From: Simon Davis
Sent: 20 March 2017 12:25
To: Planning.Responses
Subject: FW: BR/80/17/PL - Land East of Pumping Station, Highcroft Close

From: Simon Davis
Sent: 20 March 2017 12:23
To: [REDACTED]
Subject: BR/80/17/PL - Land East of Pumping Station, Highcroft Close

Site Address: Land South of Highcroft Close Bognor Regis PO22 8DS

Description of Works: Detached 1 No. two bed bungalow

PROPOSED GROUND FLOOR PLAN
& SITE BLOCK PLAN.

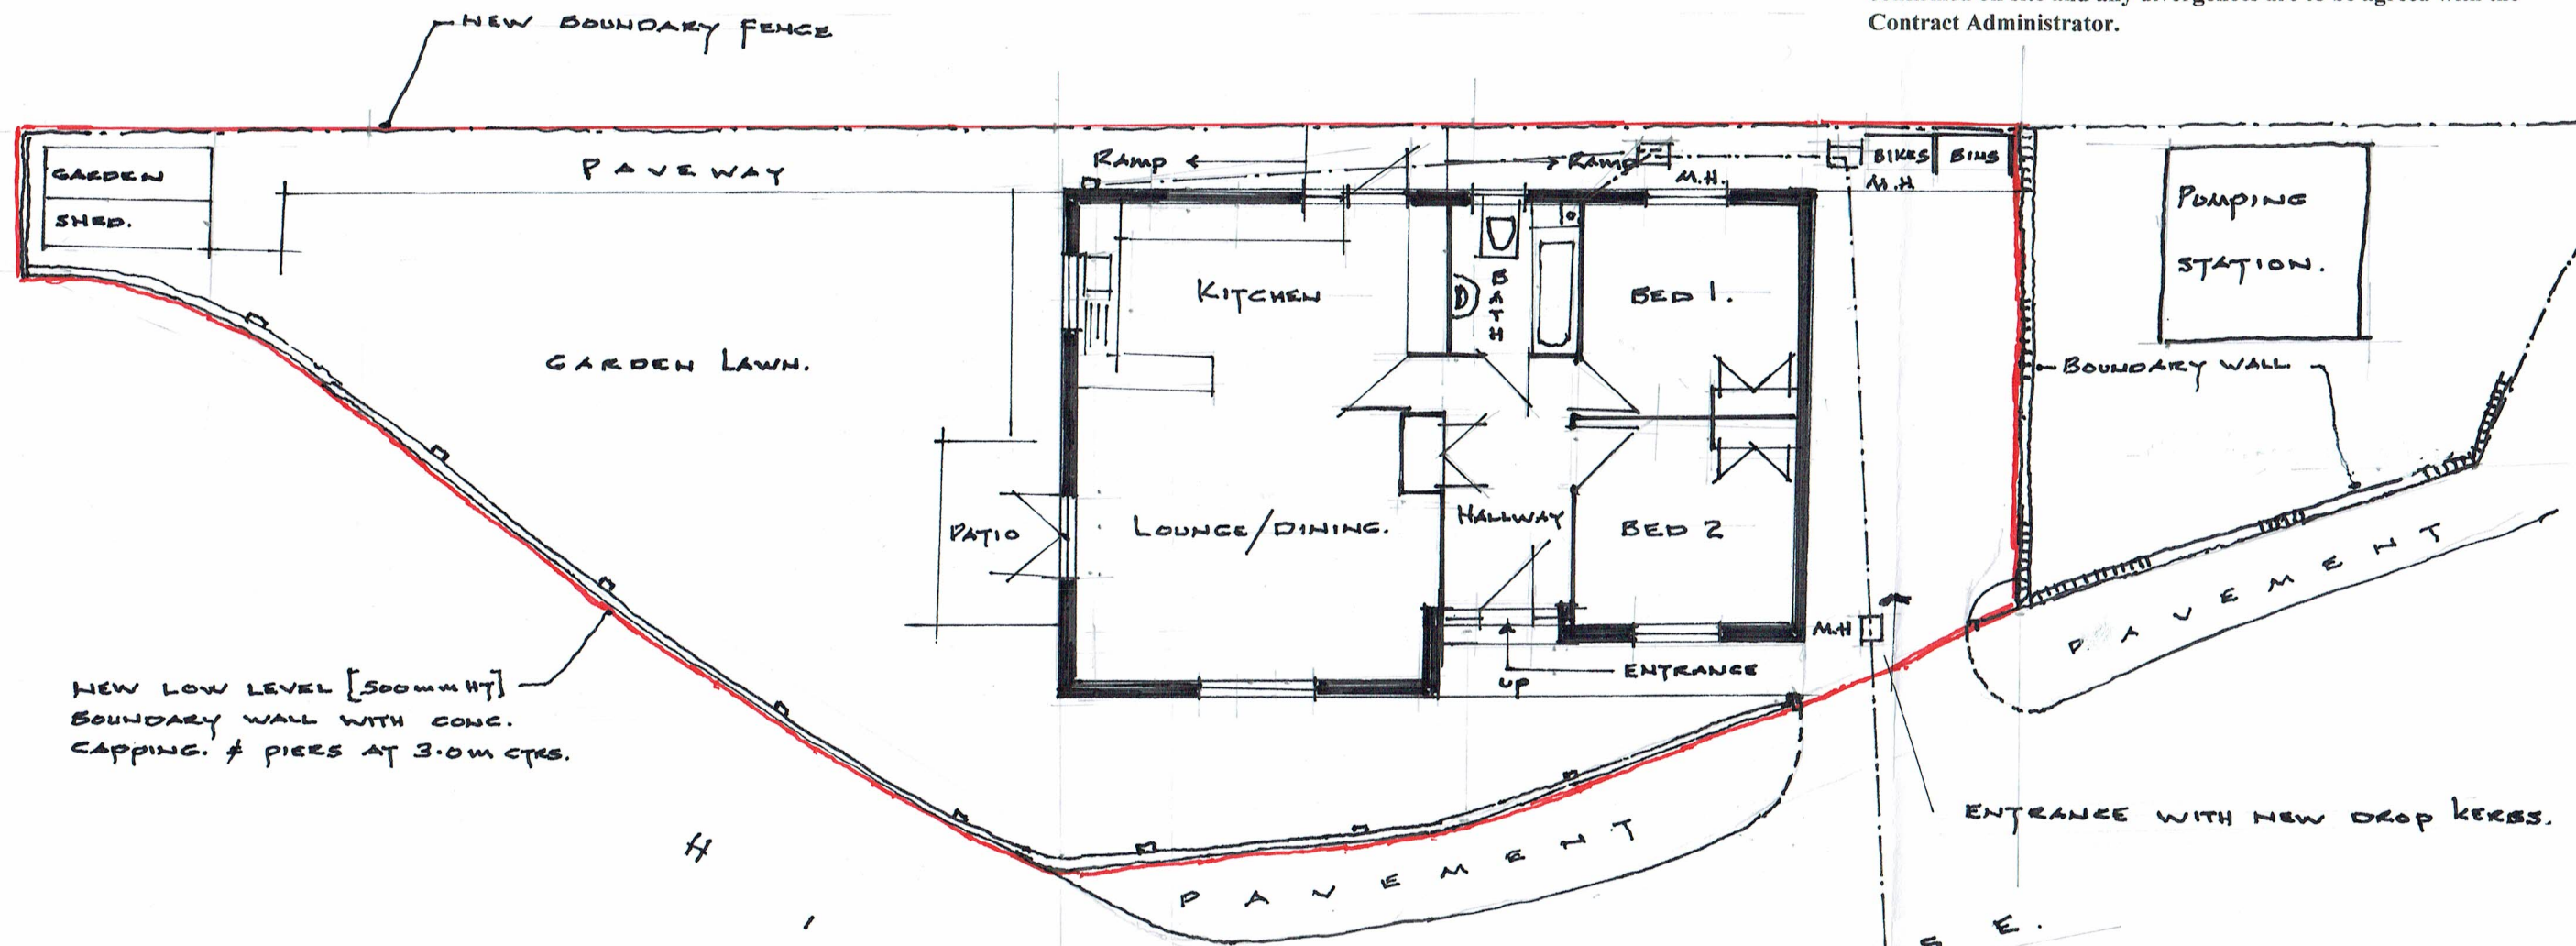
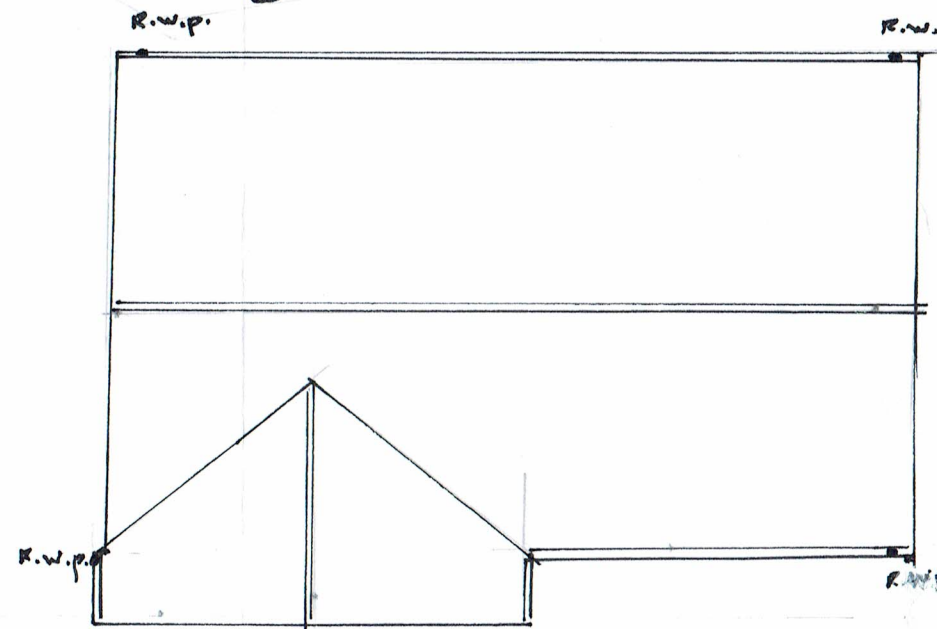
- (1) You are specifying a FFL of 2.65m. On the previous application I asked by the attached email for a streetscene to show the proposed dwelling in relation to at least 1 other dwelling (say 6 Highcroft Close) in order to demonstrate how the raised floor levels will affect the height of the dwelling in relation to others in the street. It would also be helpful if you could indicate existing ground levels on the submitted block plan.
